soils geo V_1.pdf Markup Summary 12-15-2020

Colorado Geological SurveyRMG identifies hydrocompactive soils (collapsible soils), steep slopes, erosion, seismicity, and radon and geologic hazards impacting the site. They have provided mitigation for each of these hazards that should be followed. However, no discussion is provided for sulfate attack on concrete (corrosion) and the provided laboratory testing has not evaluated soil density. Extent of collapse potential (hydrocompaction) is assessed in part by depositional environment of the material, and in part on measured water content and density of the soils along with consolidation tests. Where collapsible soils may occur has not been evaluated at this time. Both the alluvium and eolian deposits at the site are susceptible to collapse (hydrocompaction).

G RETAINING WALL DETAIL
N.T.S

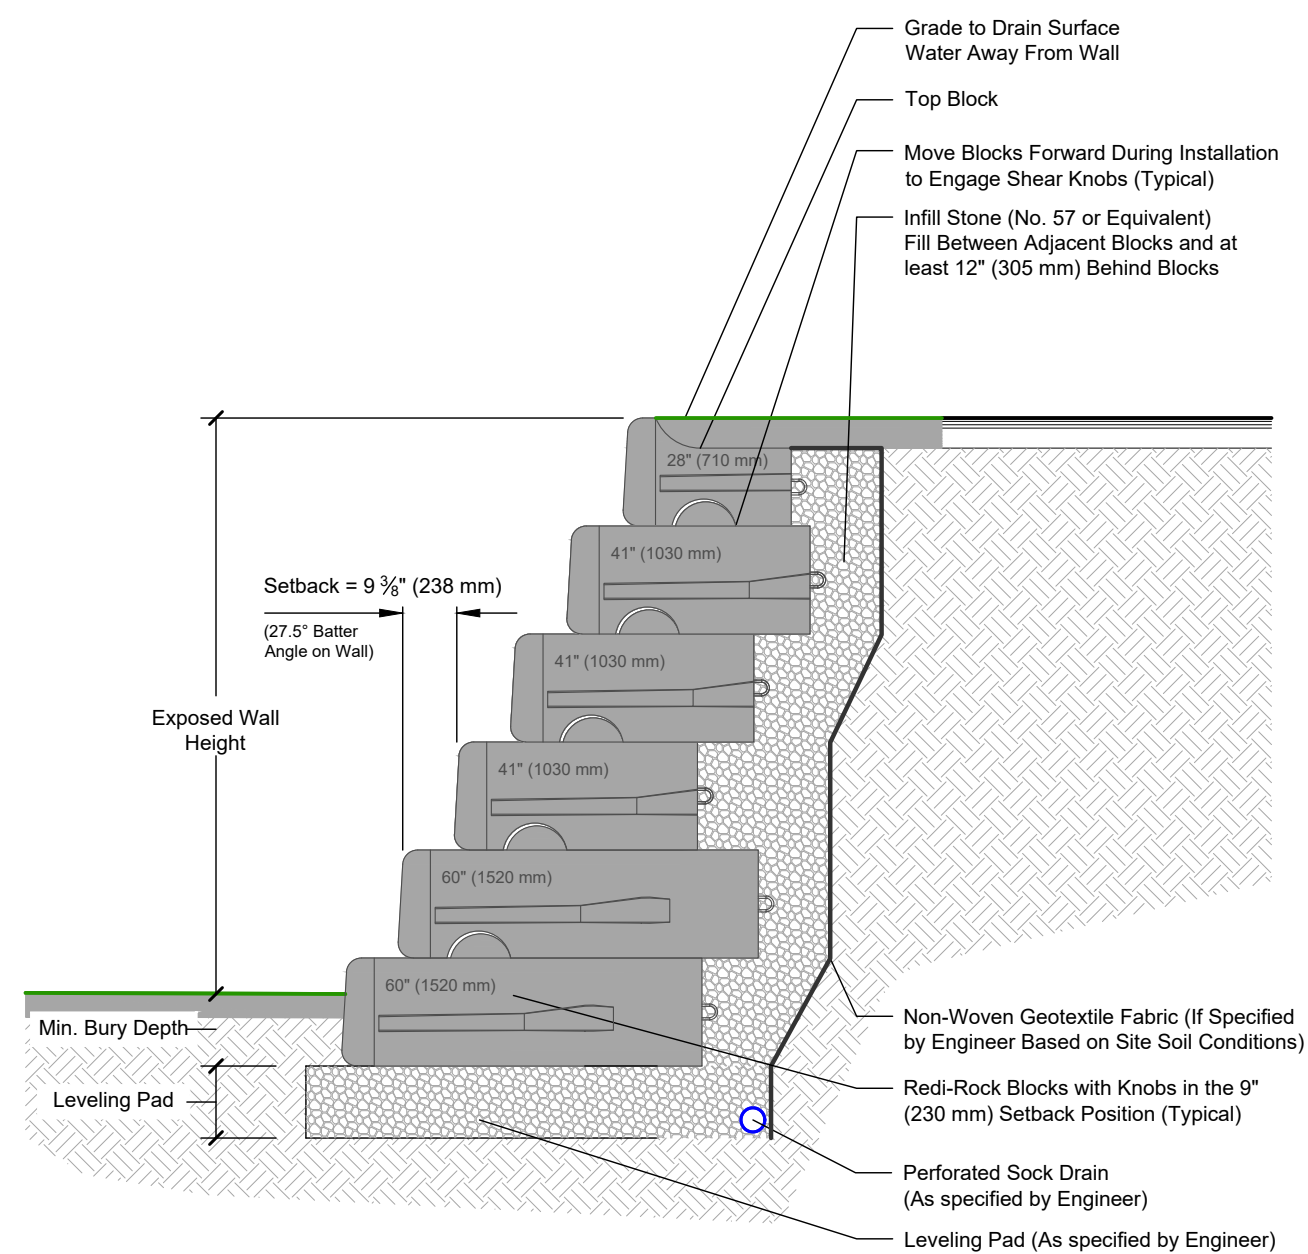
Please provide any recommendations for drainage behind the retaining wall.

RESPONSE: The retaining wall will be designed with an industry standard integral drainage system behind the wall. The drainage system will likely include a network of perforated drain pipes embedded in a geotextile fabric in the aggregate backfill behind the wall with outfalls through the wall at regular intervals, in addition to a concrete valley gutter at finished grade at the top back of wall to convey large rain events around the wall to swales and the detention pond.
